From: Plater, Roger - Oxfordshire County Council <Roger.Plater@Oxfordshire.gov.uk>
Sent: 06 January 2023 15:32
To: Simon Tucker
Cc: White, Joy - Oxfordshire County Council; Andy Bateson
Subject: 22-01488-OUT OS Parcel 5616 adj Huscote Farm and M40 J11

This email is a follow-up to the Transport comments contained within the second OCC response dated 30 November 2022 and to confirm the issues identified by our Traffic Signals officers in relation to the LinSig analysis, as discussed earlier.

JOB TITLE		LAND AT M40 J11		CLIENT		GREYSTOKE	
DRAWING TITLE							
M40 Junction 11 Gyratory							
SCALE	DRAWN BY	DATE	DRAWING No	REVISION			
1:1000@A1	RM	04/10/22	23459-06-02-GA	A

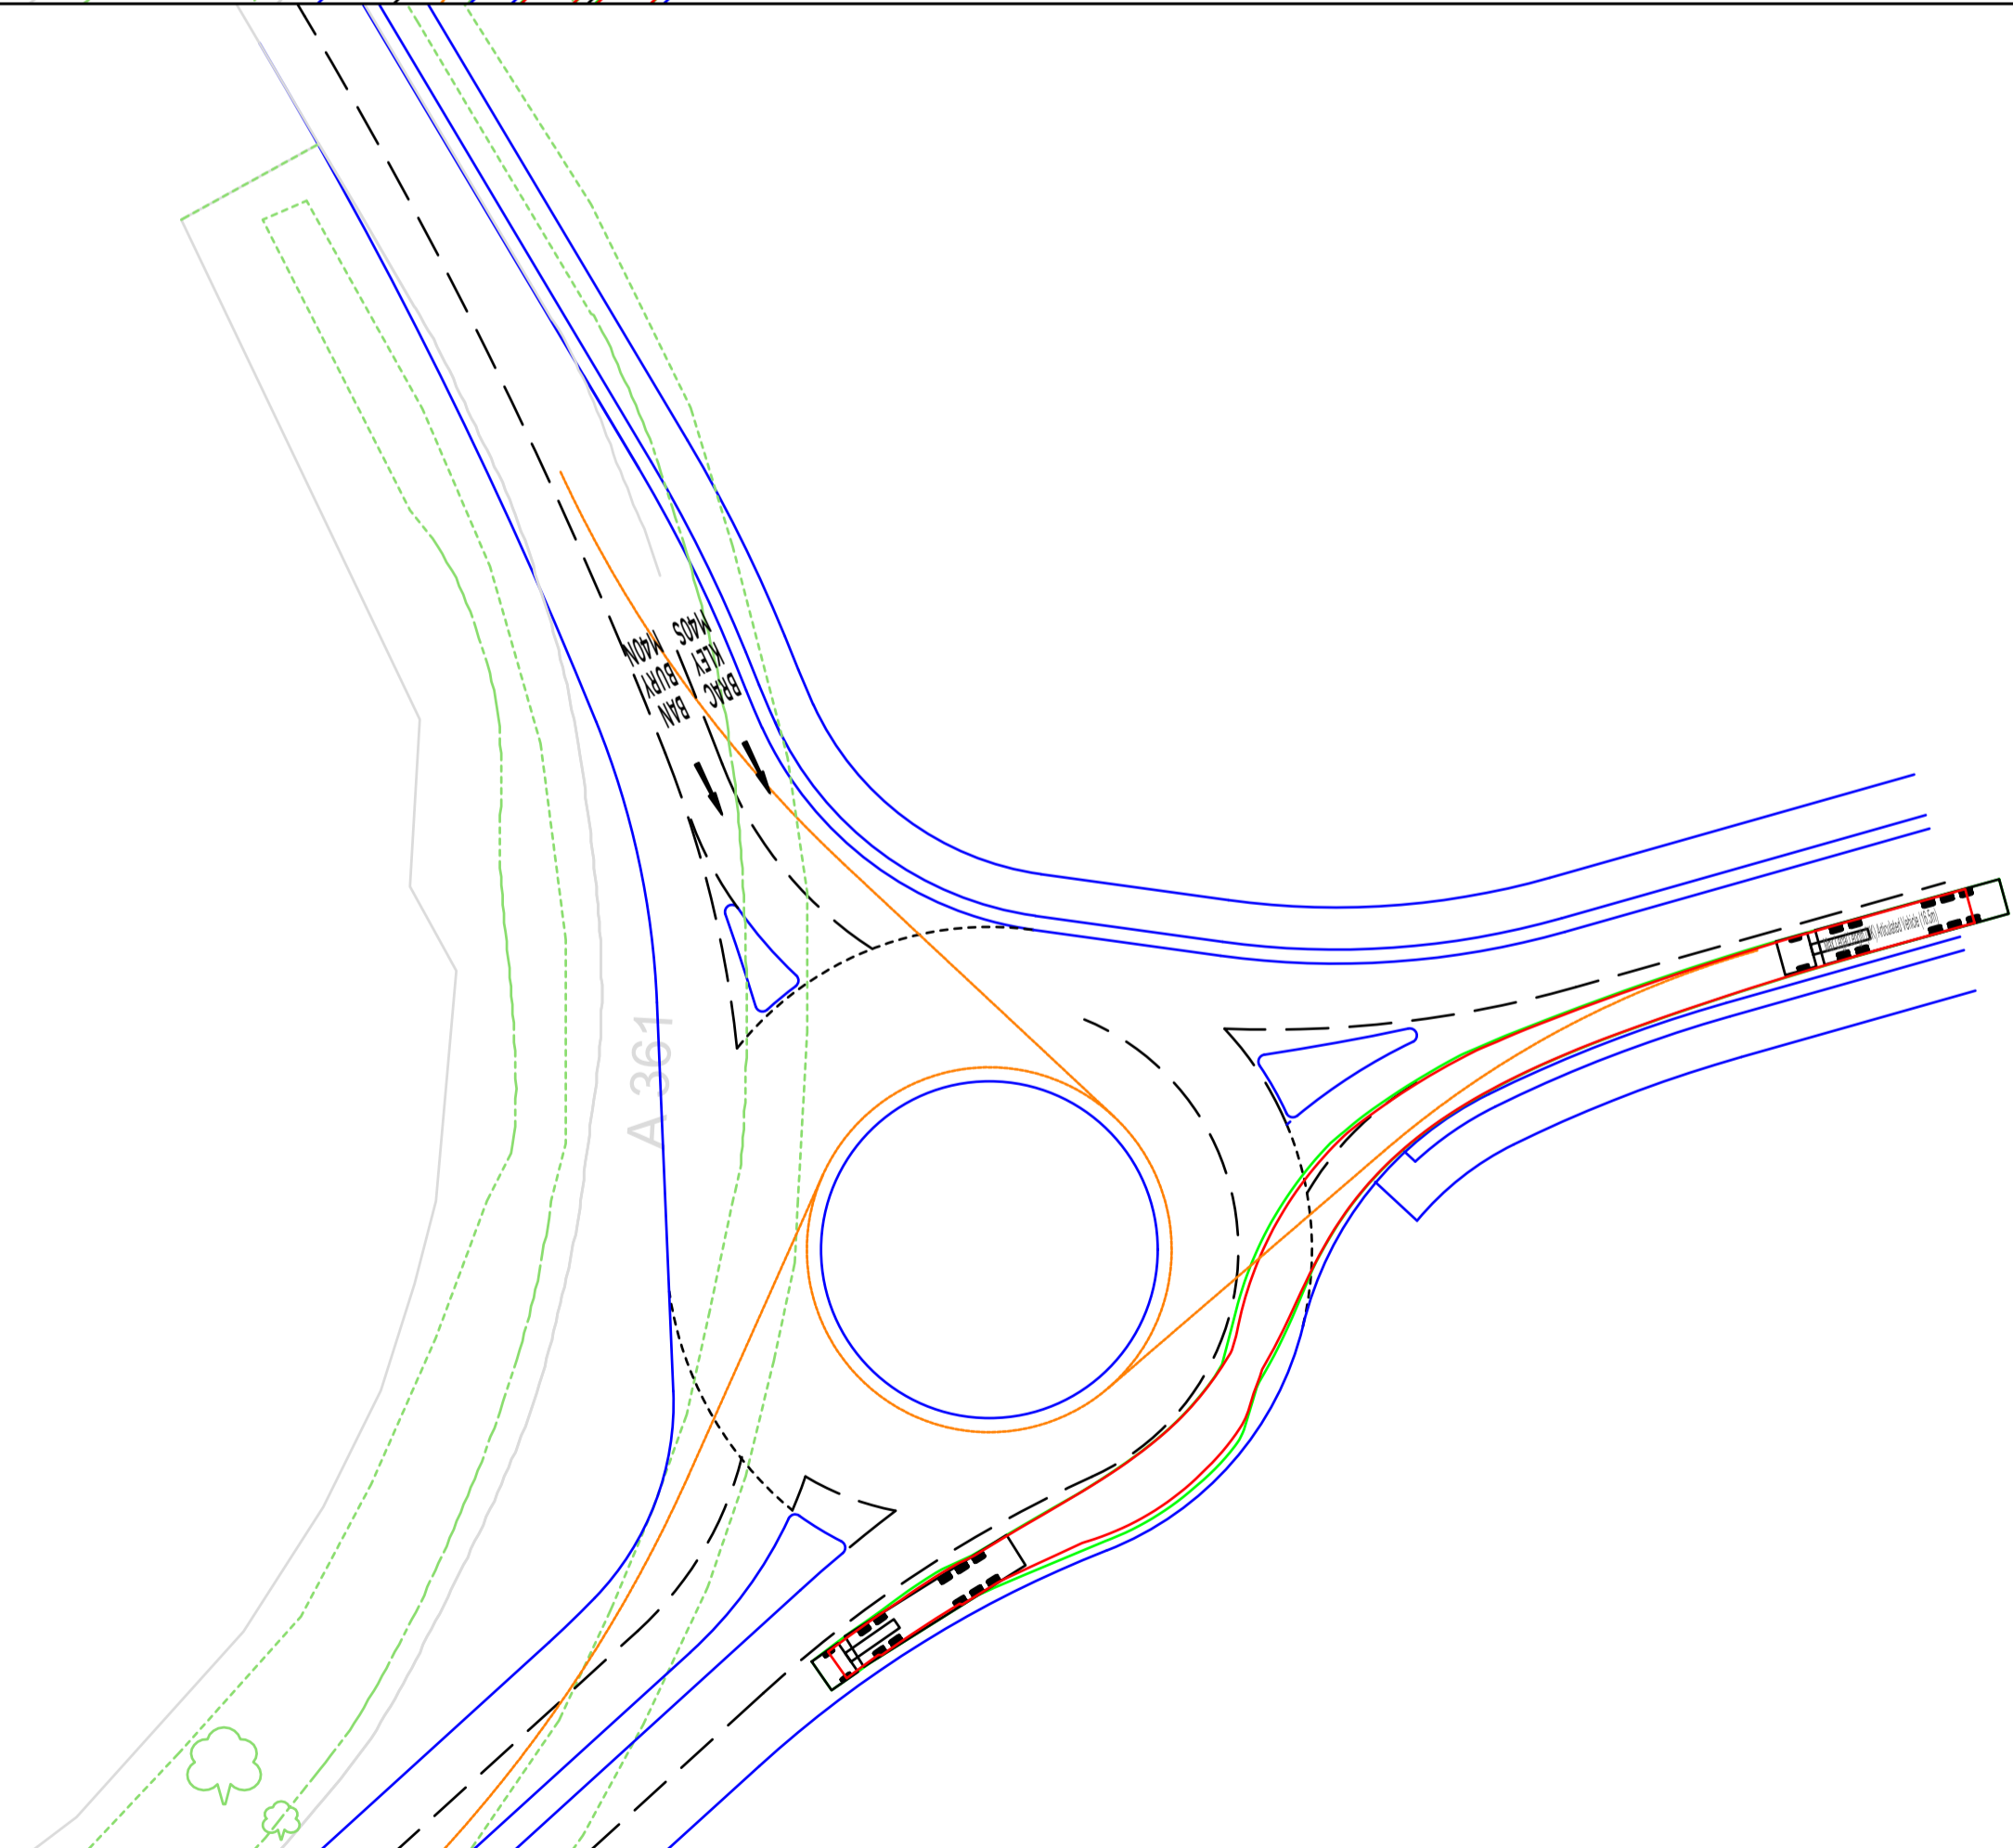
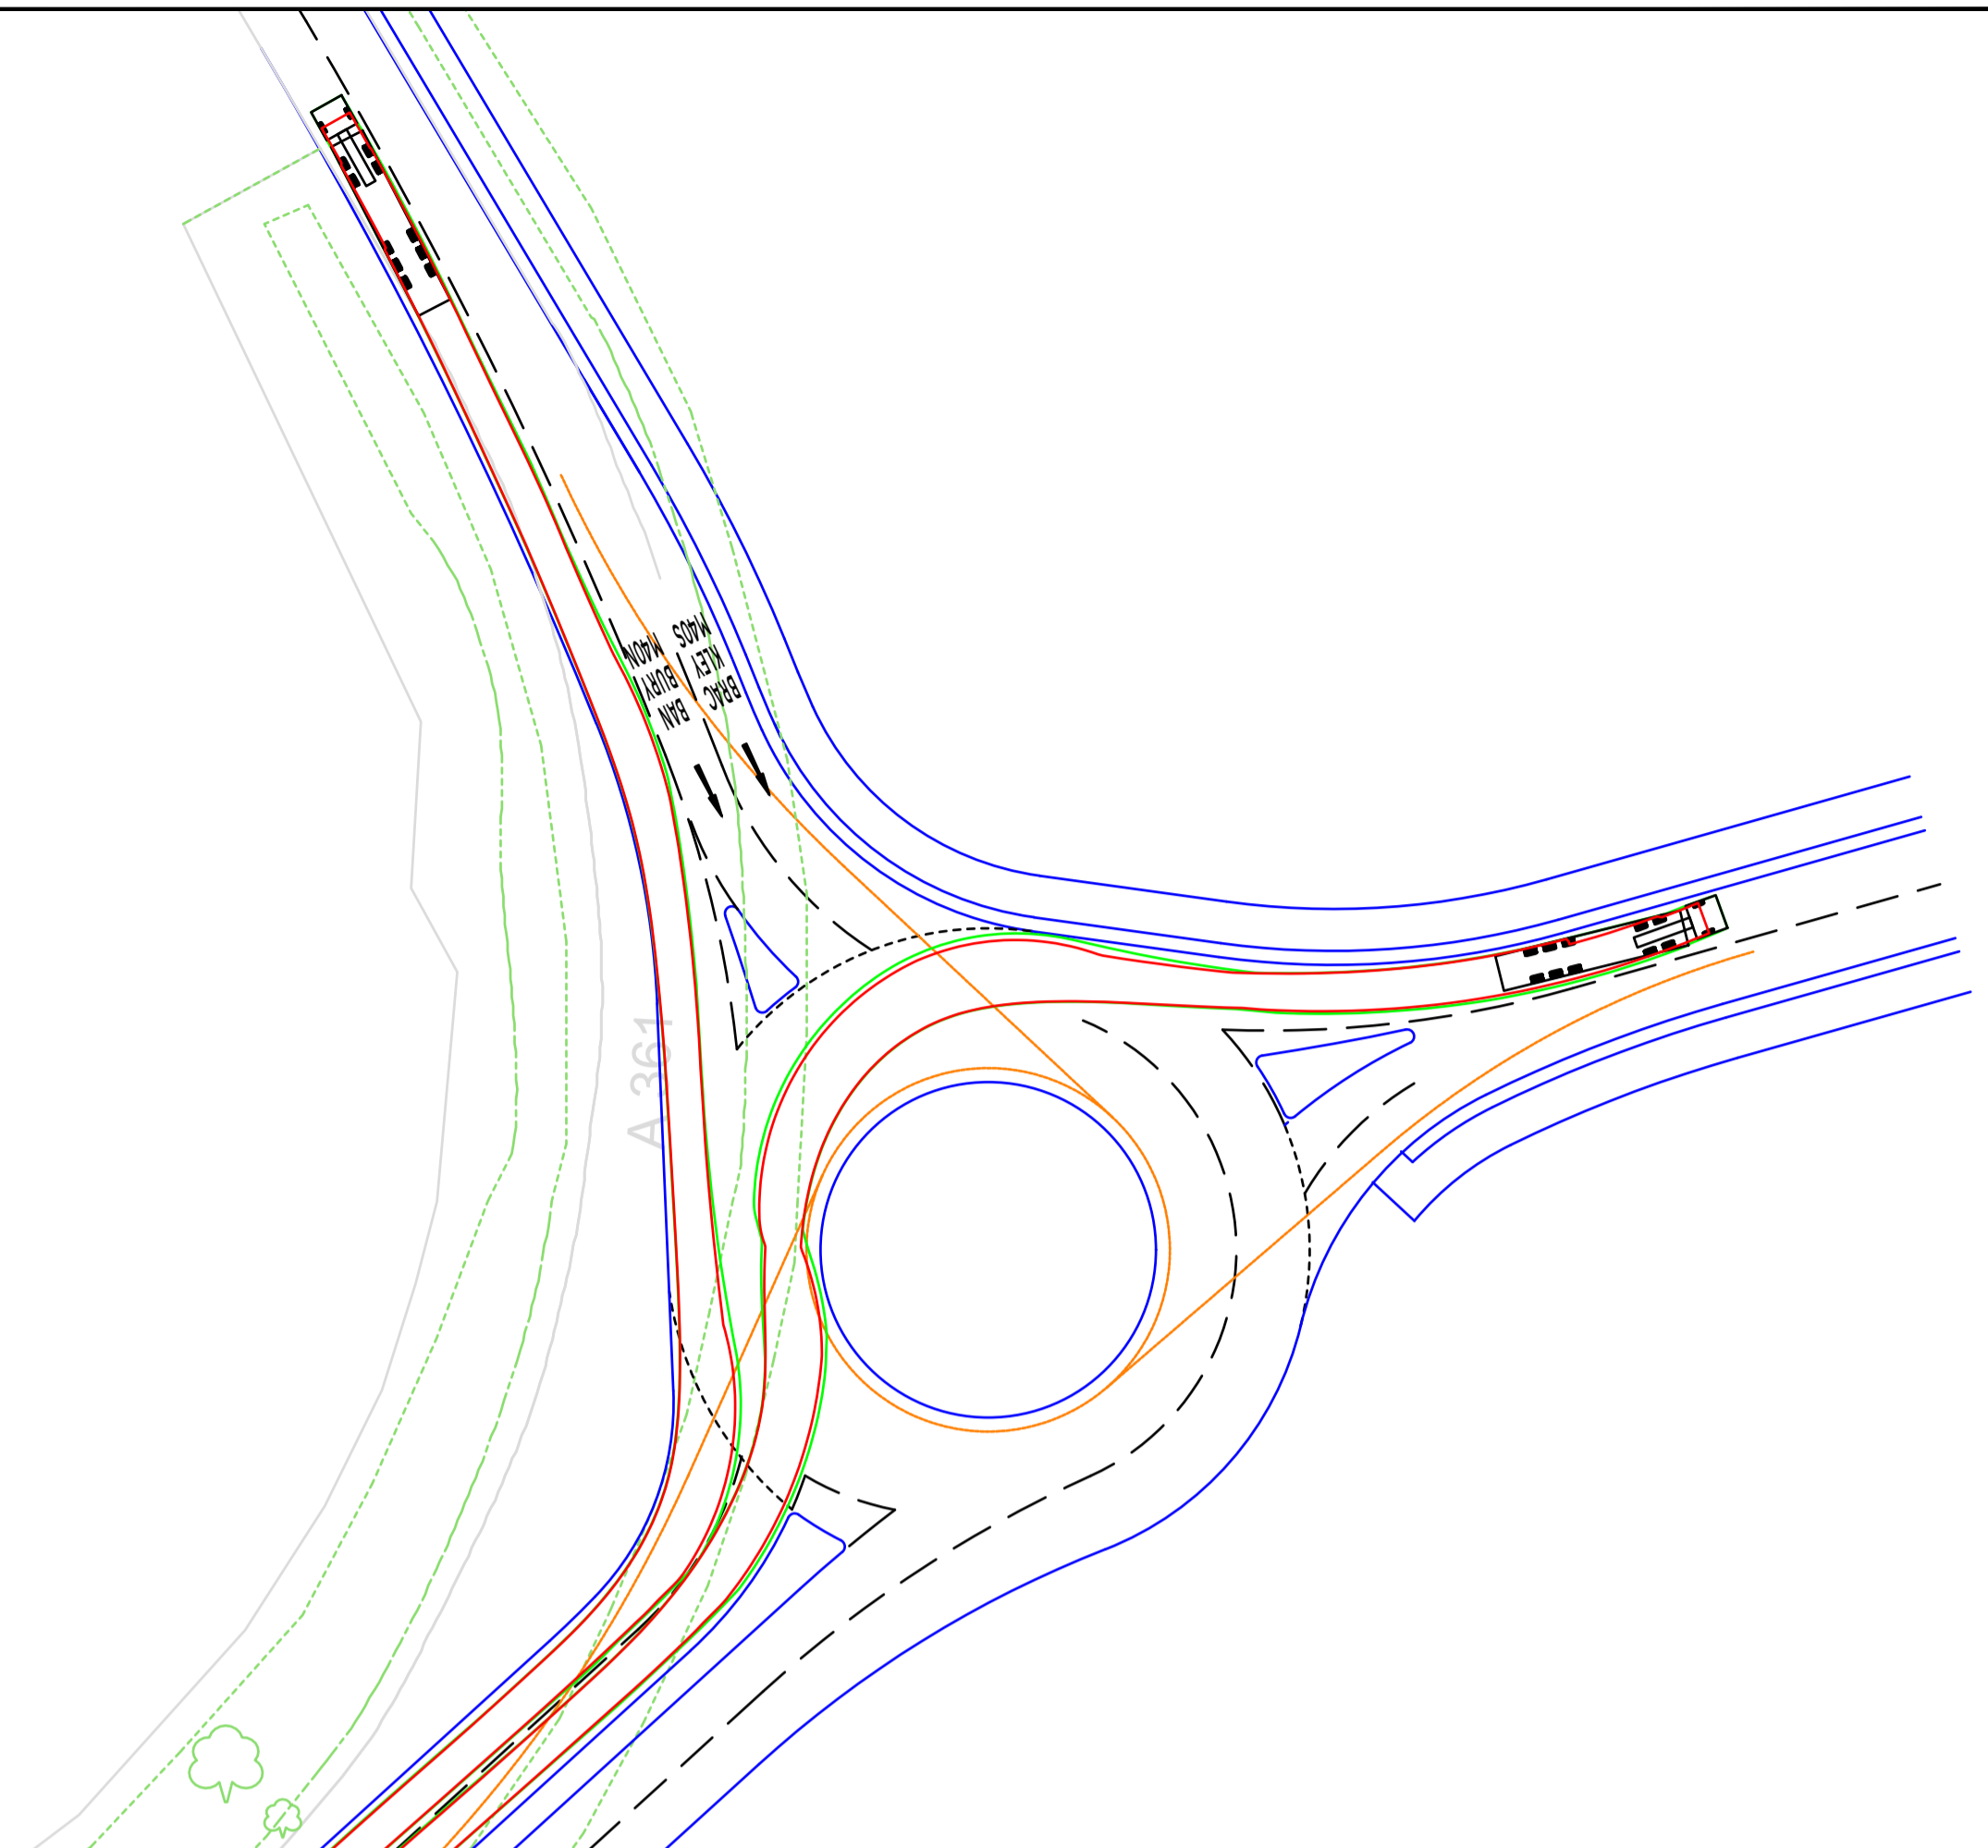
1. The layout drawing no. 23459-06-02-GA Rev. A, titled "M40 Junction 11 Gyratory" and contained in the TA Addendum, shows two lanes at the stop line where the A361 meets the roundabout. However, the LinSig model is not consistent with this as it includes a third lane for straight on and left turn to the A422. This third lane has a capacity of 10 PCUs; approximately equating to 57.5m in length. Inclusion of a third lane would be within the site boundary but will have a further implication to the embankment supporting the carriageway and potentially to the drainage as there is a pond nearby. Details of the extended embankment, including cross-sections, are required as the embankment will have to be adopted.

2. The LinSig analysis includes a flare to a third lane on the M40 southern overbridge. This is to accommodate seven PCUs so should be approximately 40m long. The layout drawing, however, shows the lane to be only approximately 17m long. Furthermore, the drawing notes "bridge unaffected". This is disputed as the proposed kerbline is outside of the current structure. Additional width will have to be constructed to incorporate a footway, utilities/infrastructure and the barrier. It is considered that the proposal would require significant works to the overbridge and the embankment.

3. The LinSig analysis contains changes to lane usage and links at various locations around the junction. These are at the M40 northbound off-slip, M40 southbound off-slip and the circulatory between the A422 Hennef Way and the M40 northbound on-slip (as well as the changes resulting from points 1 and 2 above).

The layout drawing needs to show all the proposed road markings, including arrows and destinations, and lane widths, and HGV swept paths of all movements alongside one another should be provided, to allow a review of the paths through the junction and confirm lane capacity.

DTA will review and modify the layout drawing as necessary so that it is entirely consistent with the proposals analysed using LinSig. It is also recognised that the proposed layout changes will need to be incorporated into the VISSIM analysis model when that work progresses.
